Author Details				
Name	Dr Andrew Boswell			
Position	Scientist and Consultant			
A66 Northern Trans-Pennine	20032280			
Project Link Roads Registration	20032289			
Organisation	Climate Emergency Policy and Planning (CEPP)			
Examination Principle Issues	Climate Change

DEADLINE D4 SUBMISSION SUMMARY

Drax BECCS Project	Deadline 4 (D4), March 28th 2023
Planning Examination 2022-2023	Submission

**Plate 1.1 – Annual Sources of GHG Emissions from the Proposed Scheme**

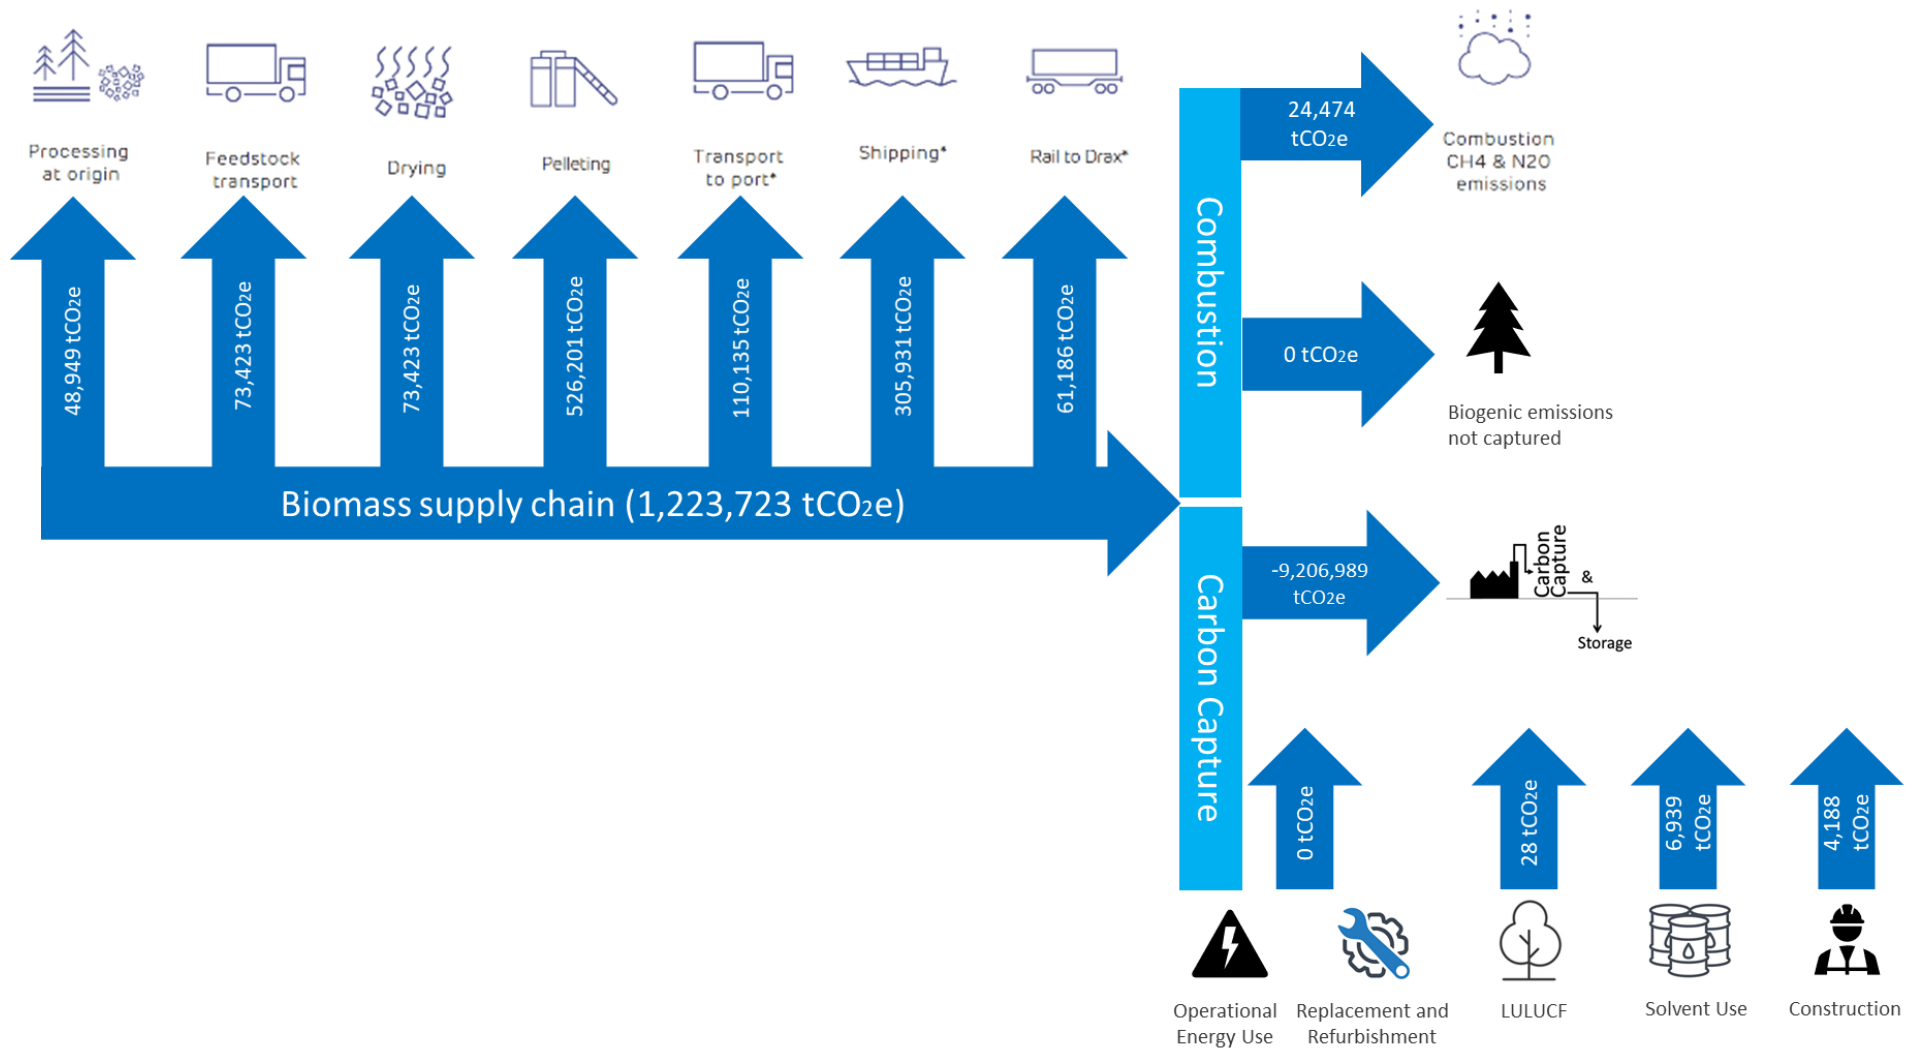
- 29 Figure CEPP.Drax.Fig-1 adapts Plate 1.1 [APP-169] to show the combustion emissions.
- 30 Paragraph 5 of Schedule 4 to the 2017 Regulations requires the environmental statement to include:

31 For the purposes of environmental assessment (as opposed to reporting national carbon inventories under the UN regime), the combustion emissions at the proposed scheme are a <u>direct effect</u> of the development. Therefore, the question is whether the combustion emissions may be treated as an internality or an externality of the EIA assessment.

This question is clearly shown in Figure CEPP.Drax.Fig-1 – are the combustion emissions represented by the dashed box included inside (internality) of the overall assessment represented by the outer non-dashed box, or are they treated outside (externality, or "zero rated")? This may also be expressed as the decision on where the "line is drawn" to which the Applicant has referred.
